**From:** Lori Seago  
**Sent:** Tuesday, October 1, 2024 4:22 PM  
**To:** Scott Weeks  
**Cc:** Hao Vo; Daniel Torres; Kari Parsons  
**Subject:** RE: Nevada/Utah - Traffic Memo comment

### VARIANCE OF USE SITE PLAN

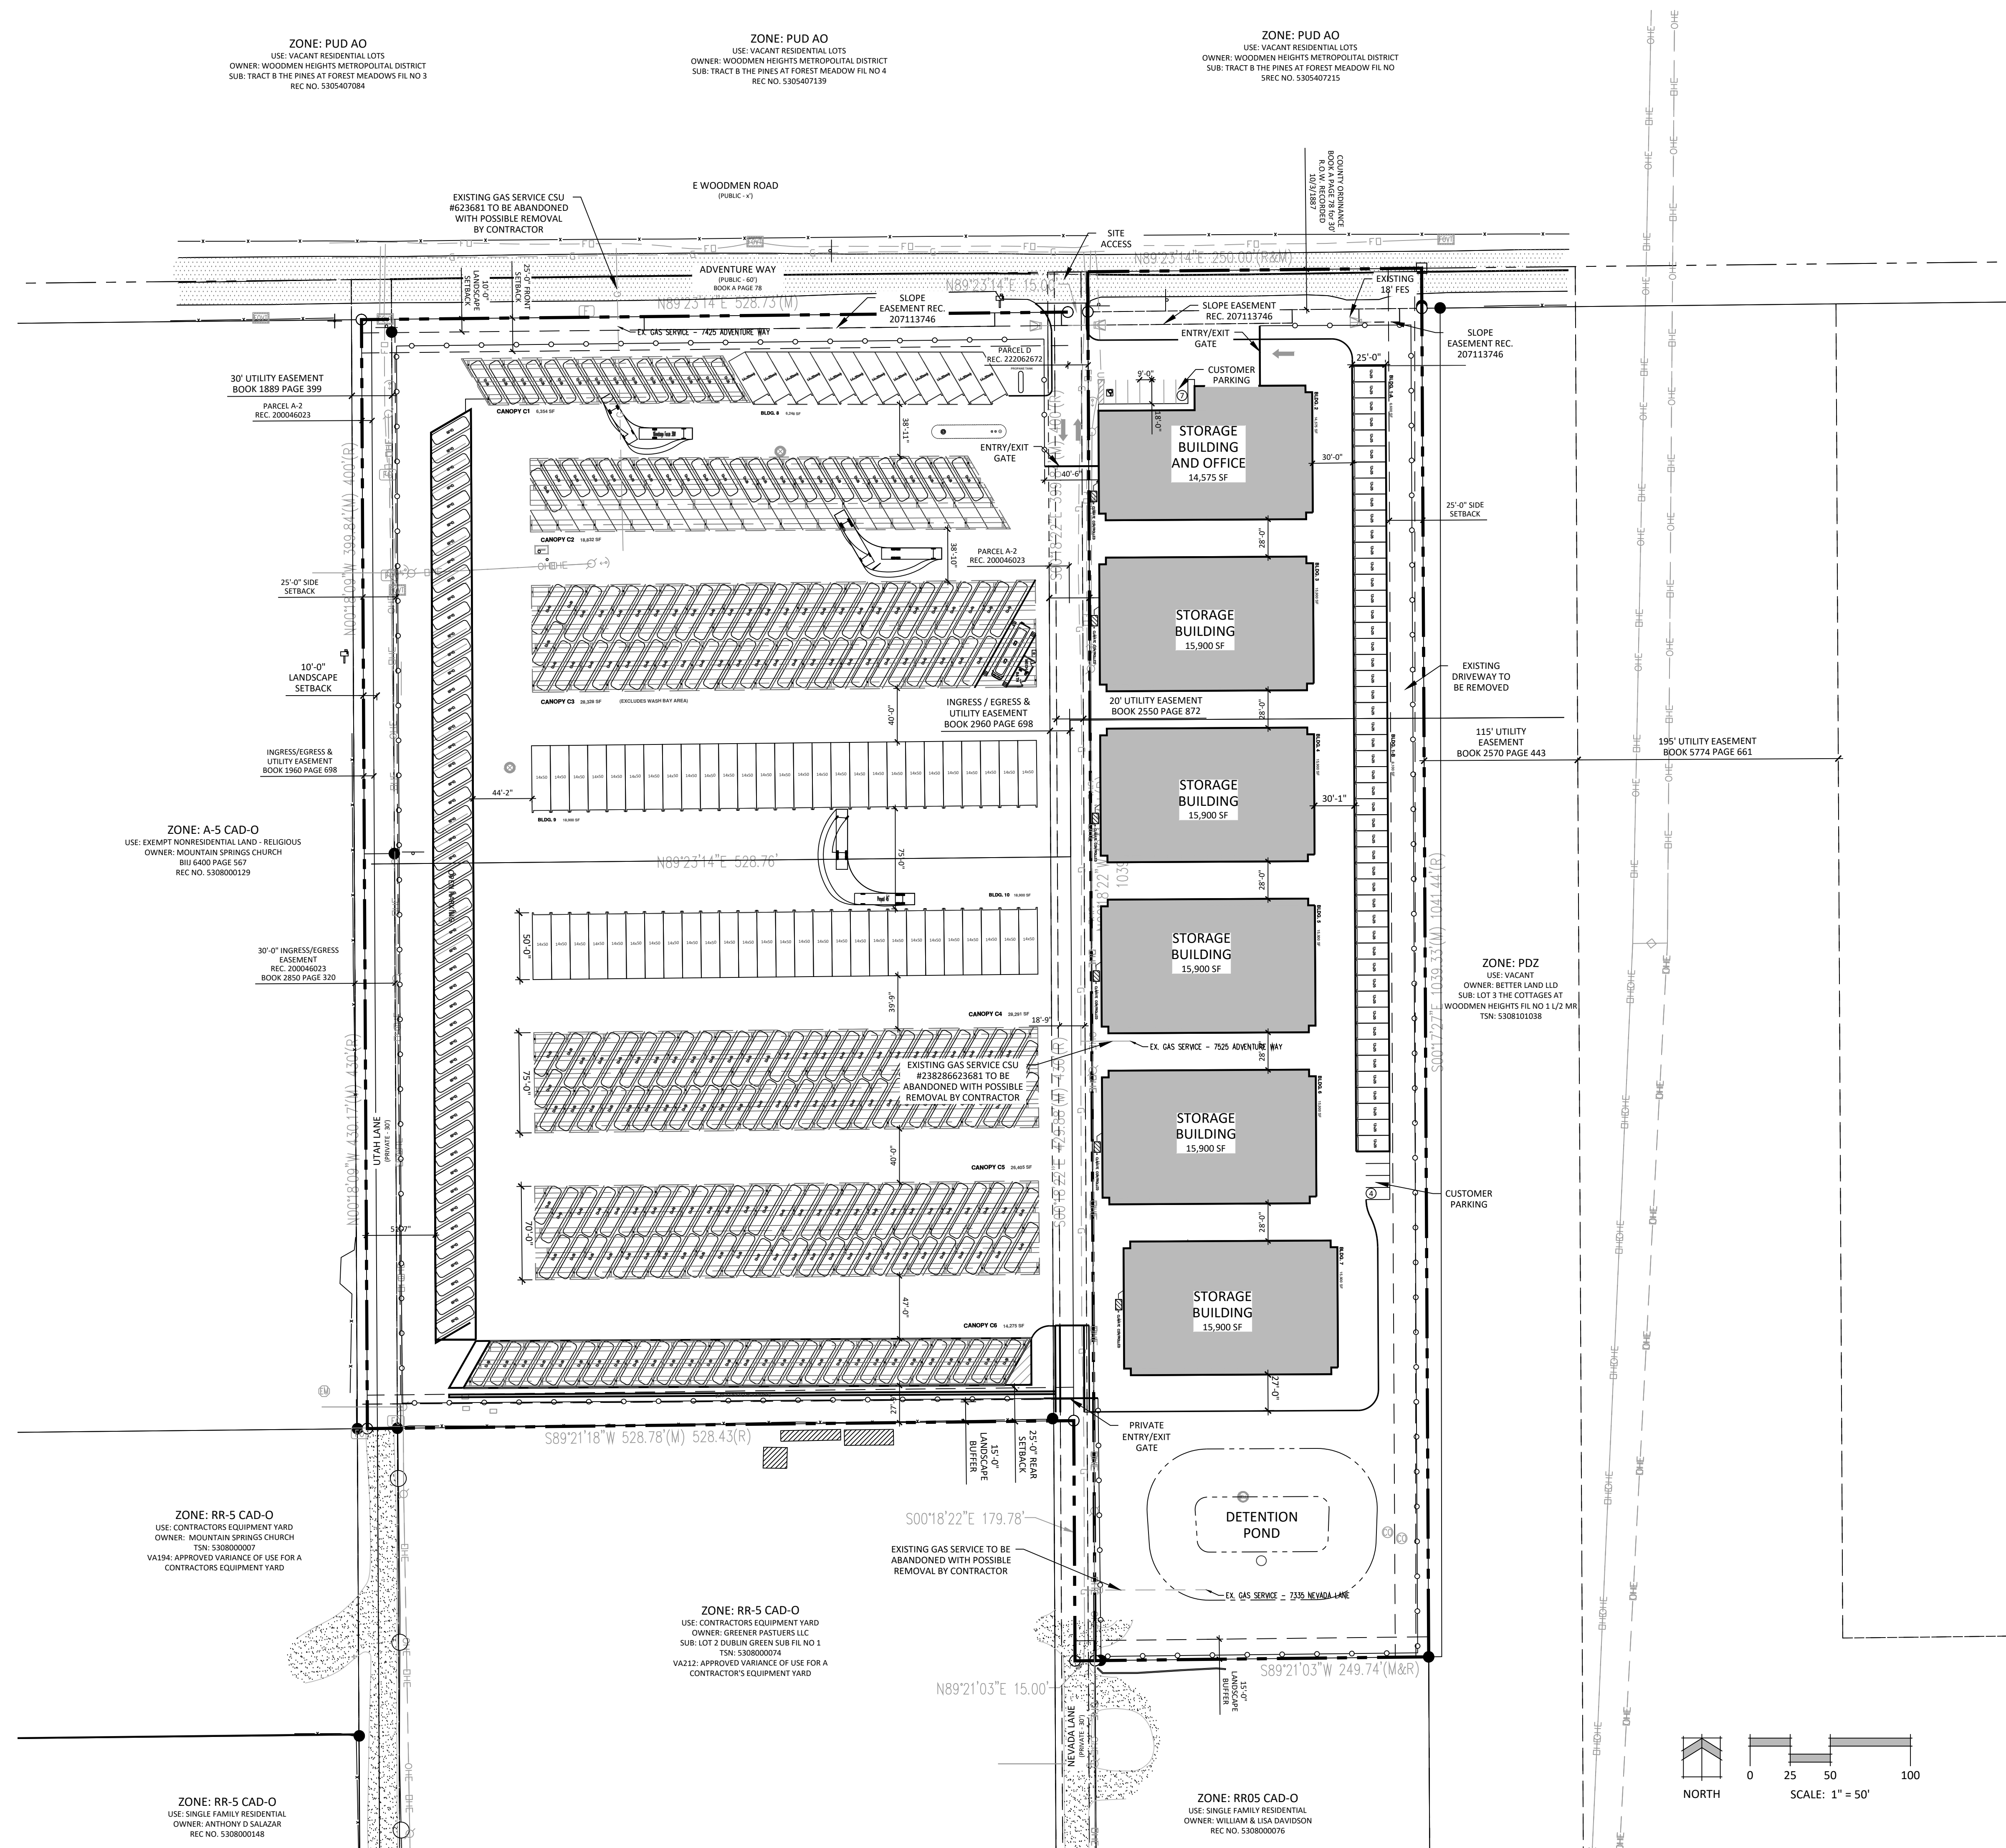
Thank you for reaching out. Since Nevada Ln will see an increase of 200 or more trips per day, the county requires it to be upgraded to a paved roadway to protect air quality. I need to verify with Gilbert on Monday regarding whether it should follow the county's standard roadway requirements. I'll provide you with the most accurate information after that.

I think the first step is to confirm whether Nevada Lane can be closed to public access. While it is a private road, based on the documentation received the road remains a prescriptive easement and available for public access. That will guide the standards that will be required to be followed regarding paving. I have included Hao Vo, staff engineer, for additional input.

Review C1: According to ECM section 2.2.7.C.3: The road is projected to have an ADT of 200 or more. All roads with a projected ADT of 200 or more shall be paved to facilitate compliance with Colorado Air Quality Control Commission Regulation No. 1, Emission Control Regulations for Particulates, Smokes, and Sulfur Oxides for the State of Colorado.

Based on the information provided and the county attorney's office review of the Decree Quieting Title recorded document (reception no. 222062672), there is insufficient evidence that allows Nevada Road to be fully closed and restricted from public access. As Gilbert advised Hao Vo, if Nevada Ln is closed, it does not need to meet the county's standard pavement requirements. However, if it remains open, it must comply with the county's pavement standards. Until it can be verified that Nevada Lane can be closed, any improvements will need to meet county standards.

Gilbert confirmed that if Nevada Ln is closed, it does not need to meet the county's standard pavement requirements. However, if it remains open, it must comply with the county's pavement standards.
